Phone: 0300 123 6780  
Email: [developeras@lancashire.gov.uk](mailto:developeras@lancashire.gov.uk)  
Your ref: 3/2025/0507  
3/2025/0508  
Our ref: 3/2025/0507/HDC/KW  
3/2025/0508/HDC/KW  
Date: 06 October 2025

**Location:** Lower Reaps Farm Whinney Lane Mellor BB2 7EL  
**Proposal:** Application for Planning Permission for conversion of barn to create new dwelling. Demolition of existing farm block.  
**Grid Ref:** 366124 430211

The Local Highway Authority (LHA) are in receipt of a listed building consent and a planning application for the conversion of barn to create new dwelling. Construction of garage block. Demolition of existing farm block at Lower Reaps Farm, Whinney Lane, Mellor.

pl.10

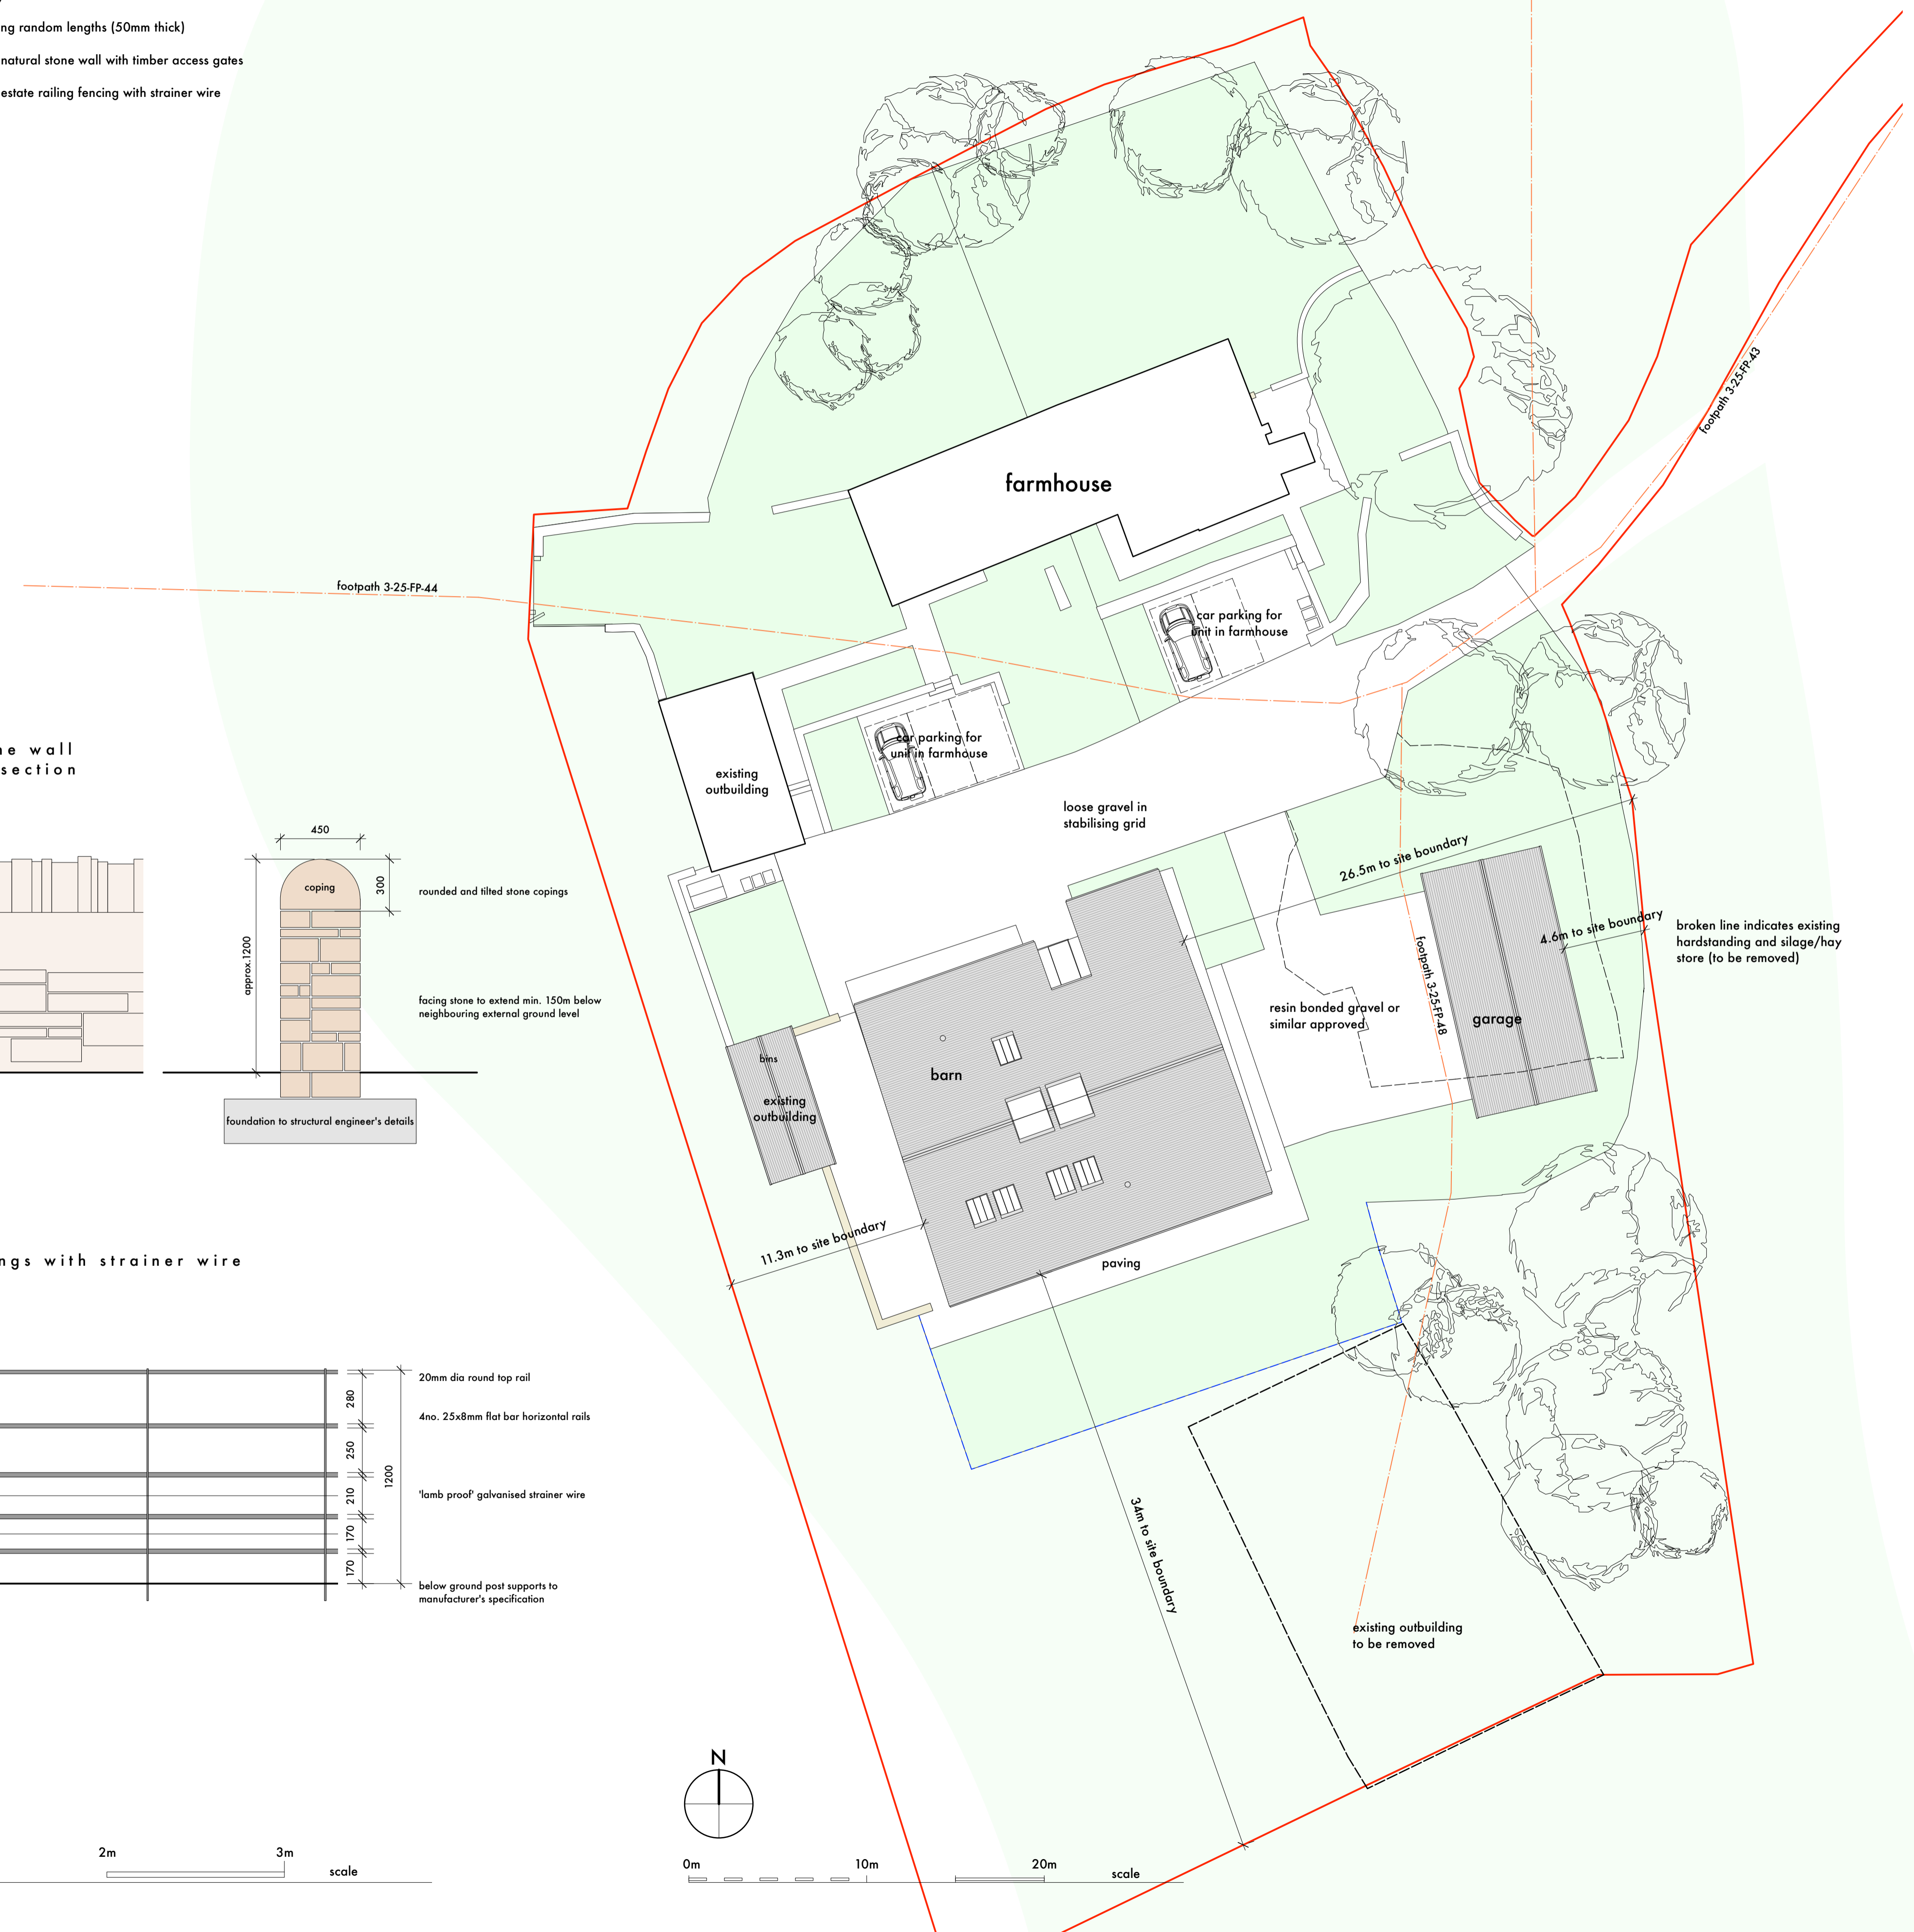
The LHA have reviewed drawing number pl.10 Rev E titled "Proposed Site and Landscaping Plan" and is aware that the proposed parking arrangements for the existing farmhouse and the proposed barn conversion are in line with the LHAs parking guidance as defined in the Joint Lancashire Structure Plan. A hard-standing area to the East of the barn conversions will provide parking provisions for the new dwelling as well as parking provisions for the existing farmhouse fronting the farmhouse.

**Reason:** in the interest of highway safety.
3. The development hereby permitted shall not be occupied until such time as the parking and turning facilities have been implemented in accordance with drawing number pl.10 Revision E. Thereafter the onsite parking provision shall be so maintained in perpetuity.
